Appeal Decision

Appeal Ref: APP/R4408/D/22/3309659

3 Colster Close, Gawber, Barnsley S75 2LR

- The appeal is made under section 78 of the Town and Country Planning Act 1990 against a refusal to grant planning permission.
 - The appeal is made by Mr Mark Brazier against the decision of Barnsley Metropolitan Borough Council.
 - The application Ref 2022/0782, dated 22 July 2022, was refused by notice dated 6 October 2022.
 - The development proposed is loft conversion.
-

REAR ELEVATION

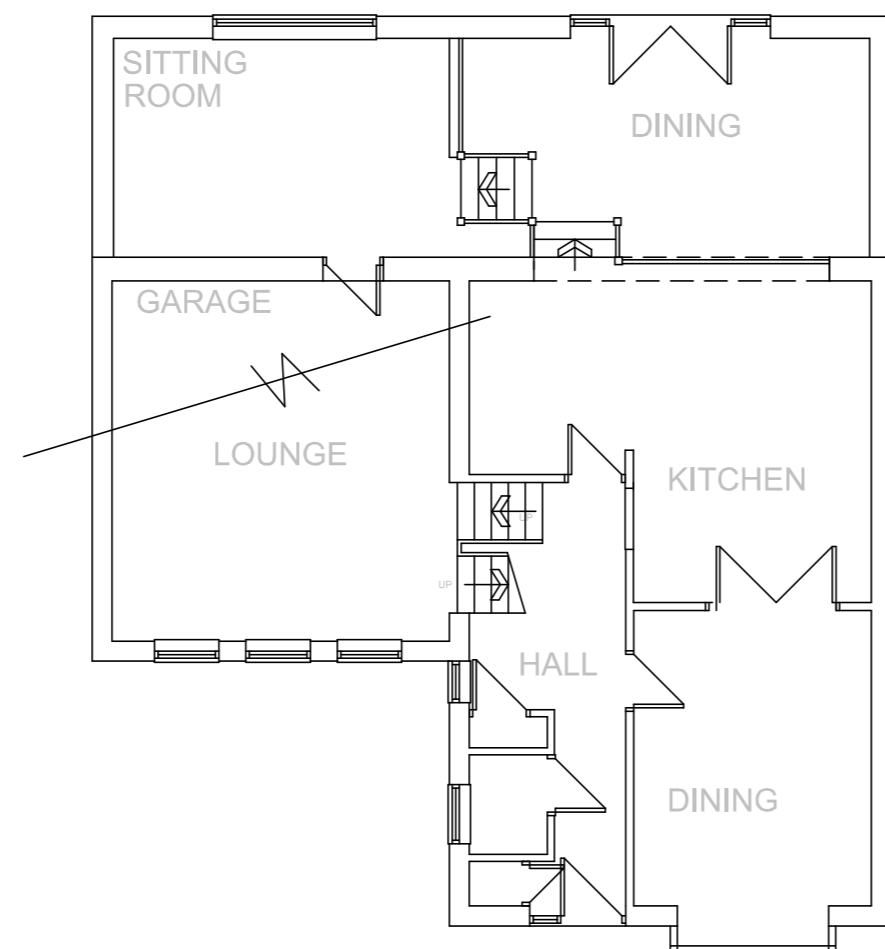
7. The proposed rear flat roofed dormer would be of a horizontal emphasis, and it would project from the roofscape to a significant depth and height to a point where its outer face would align with that of the rear elevation. It would occupy almost the full width of the rear of the side elevation and give the appearance of a three-storey property.

8. The rear elevation of the host property faces a field, and as such the proposal would not be directly within public view. However, it would be within public view from along Wharfedale Road. At my visit, I saw a substantial gap in the built frontage between the two-storey property at No.49 Wharfedale Close and the single storey bungalow at No.51, which occupies the corner plot to Colster Close. While a hedge fronts this gap to the road, the gap at the middle to upper level is open. The proposed rear dormer's scale, together with the increased bulk and mass of the side elevation would be clearly seen at this point, along with the altered roof pitch to the side elevation. The proposed roofscape would appear as overly dominant in relation to the prevailing lower roofscape along and at the corner of Colster Close. It would appear discordant in the context of the prevailing character of single storey dwellings.
